Your Ref: ECH1065
Our Ref: BE/127/12/A
Please ask for:
Mr C Cronin

Town & Country Planning (Control of Advertisement) (England) Regulations 2007 (as amended)

Various non-illuminated & internally illuminated signage
Former LEC Site Shripney Way Bognor Regis

The Planning and Licensing Committee discussed the Sainsbury's Planning Application, BE/127/12/A at their meeting on the 18th December 2012. Please find their comment below:

Proposed Welcome
Wall & Vinyl Details 2

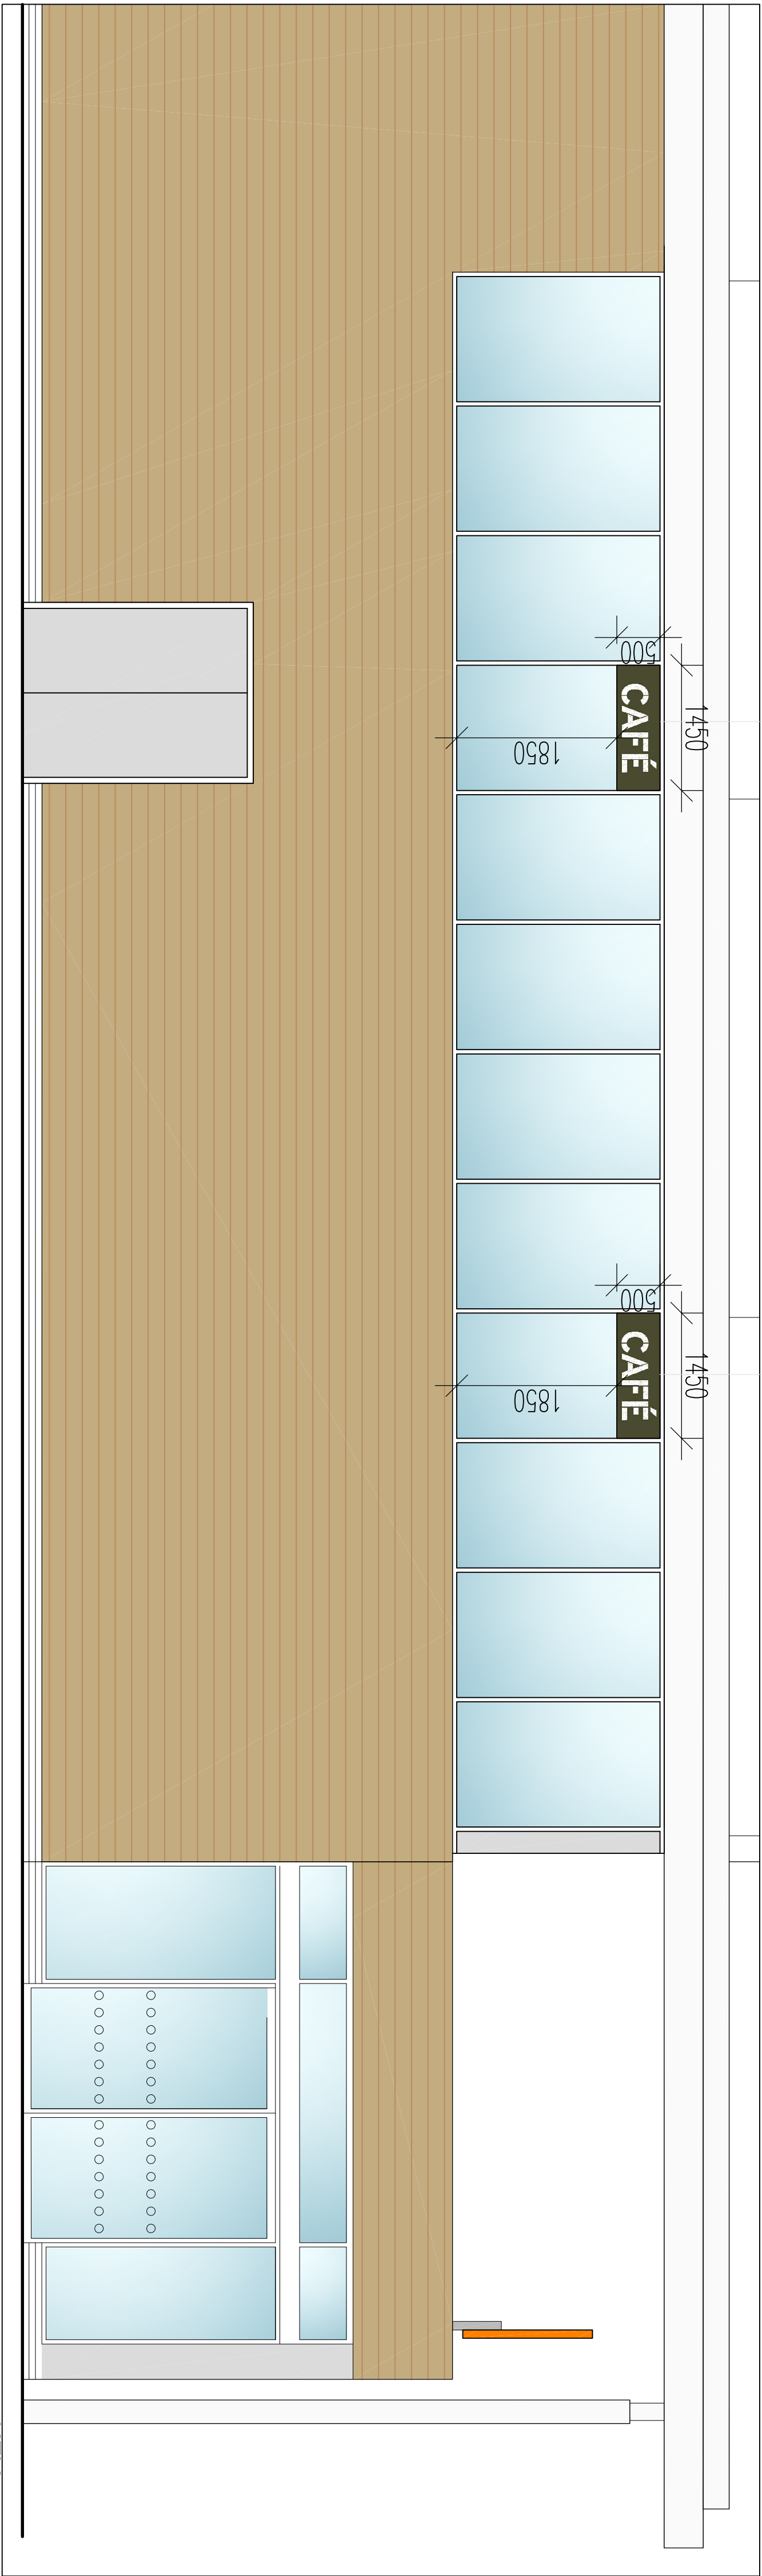
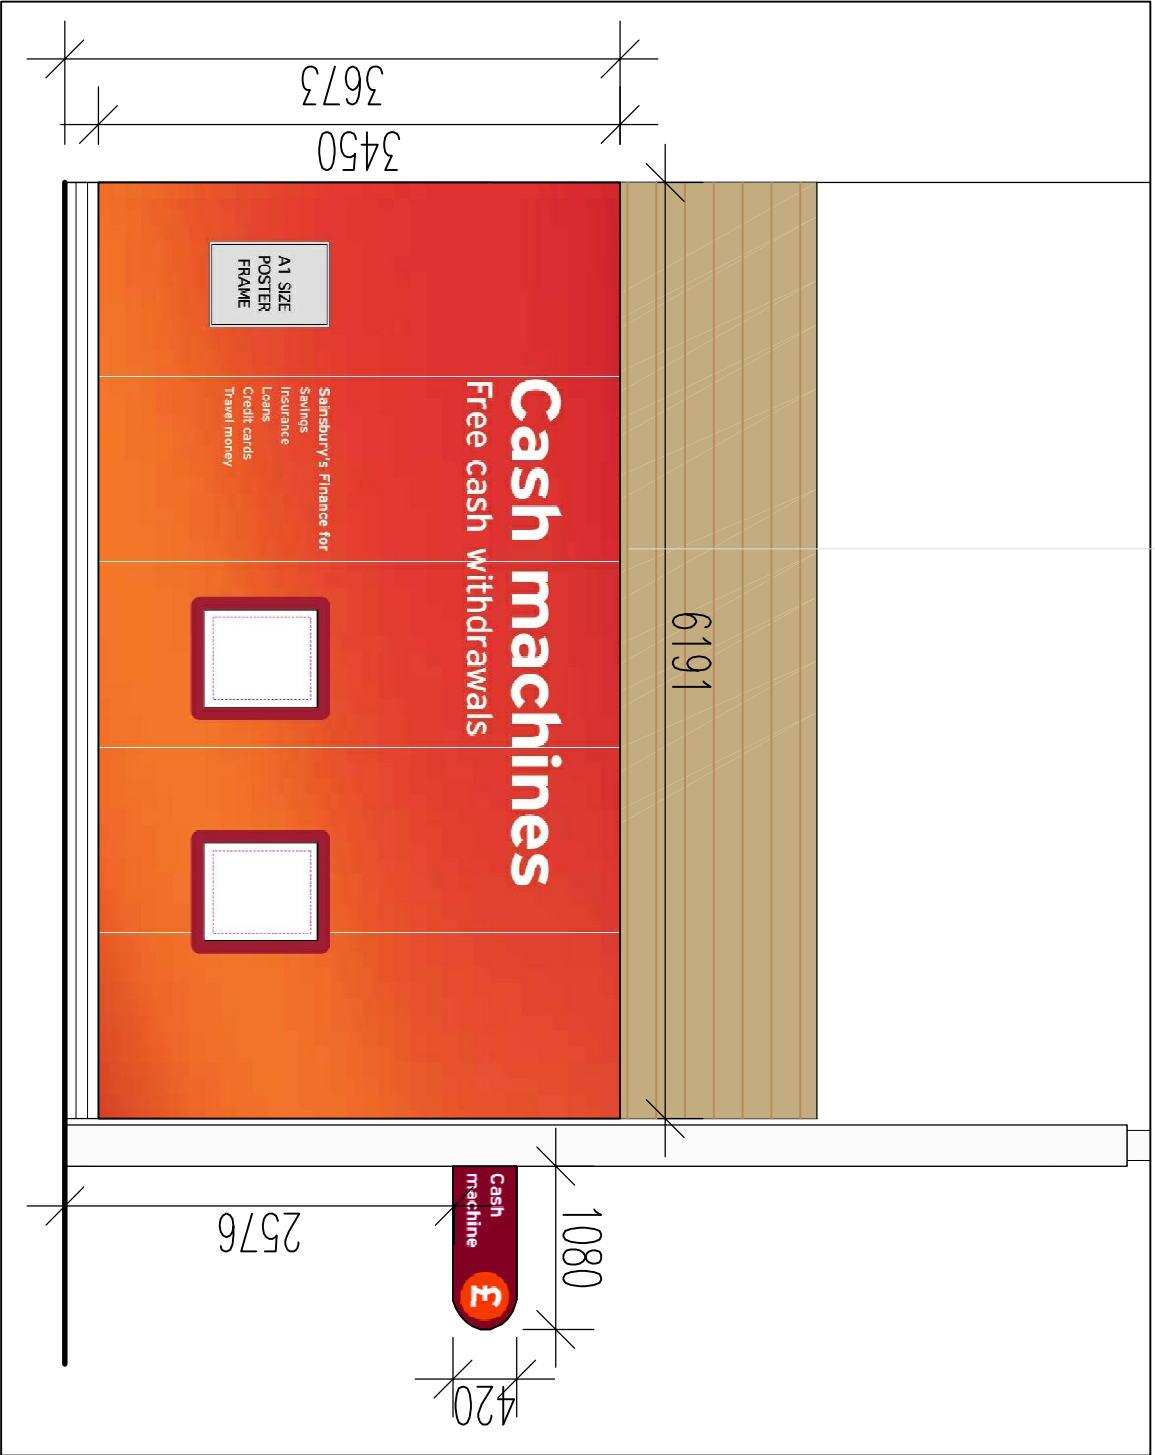
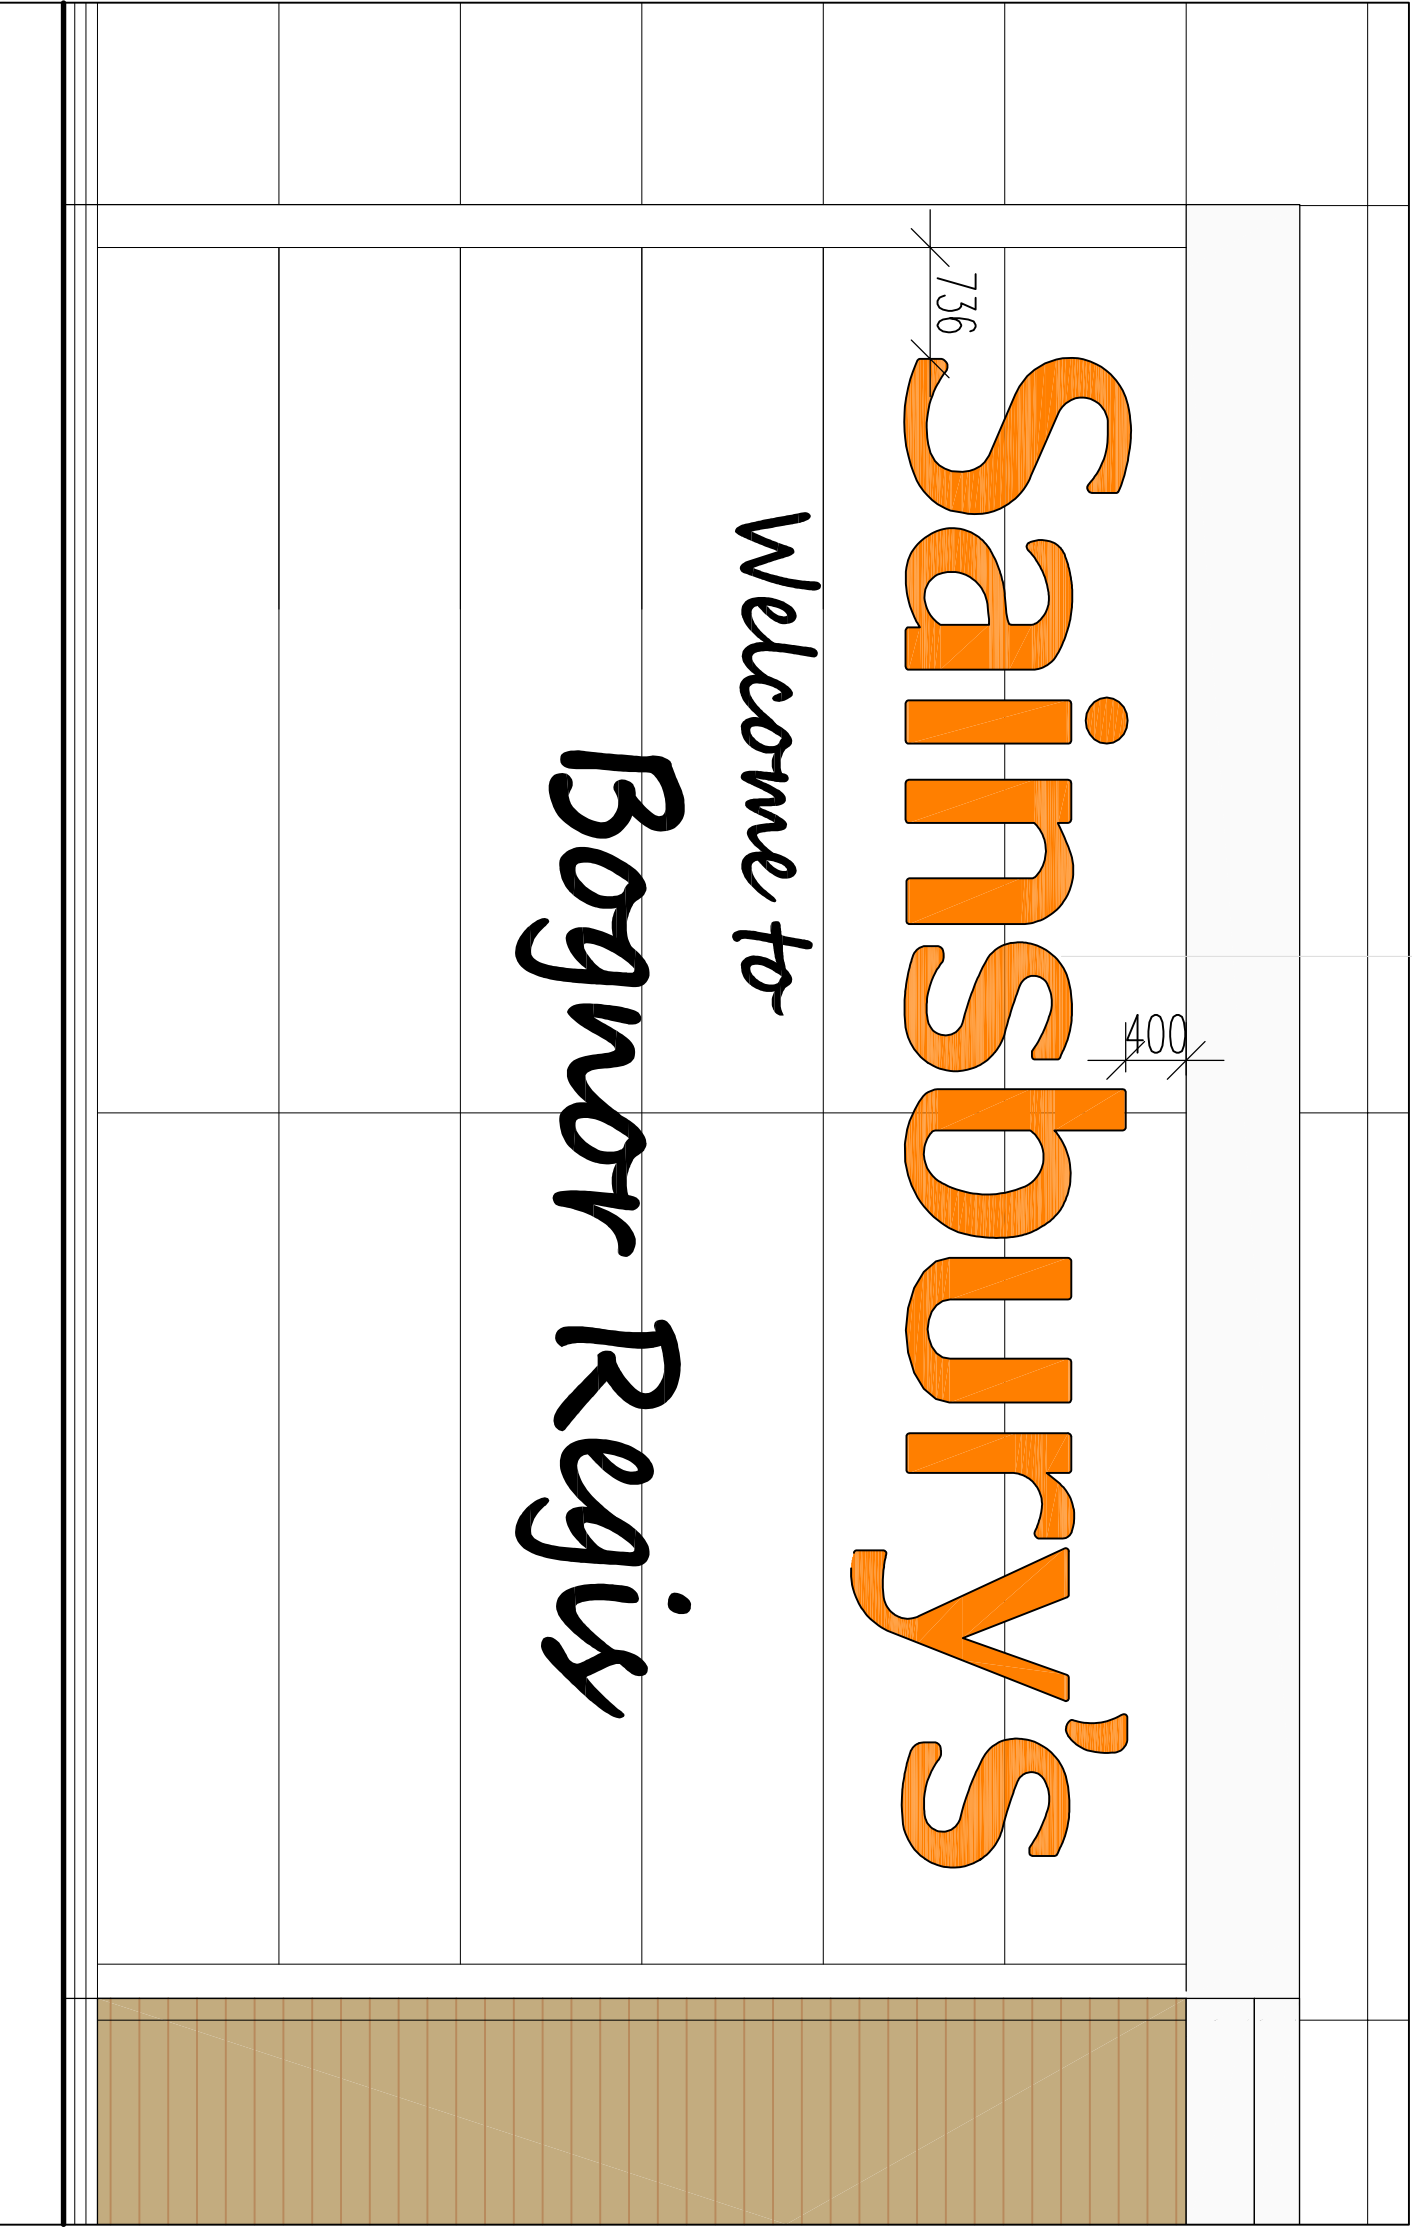
NO OBJECTION but the Committee expressed their disappointment that the 'Welcome to Bognor Regis' is not more prominent as had been previously promised
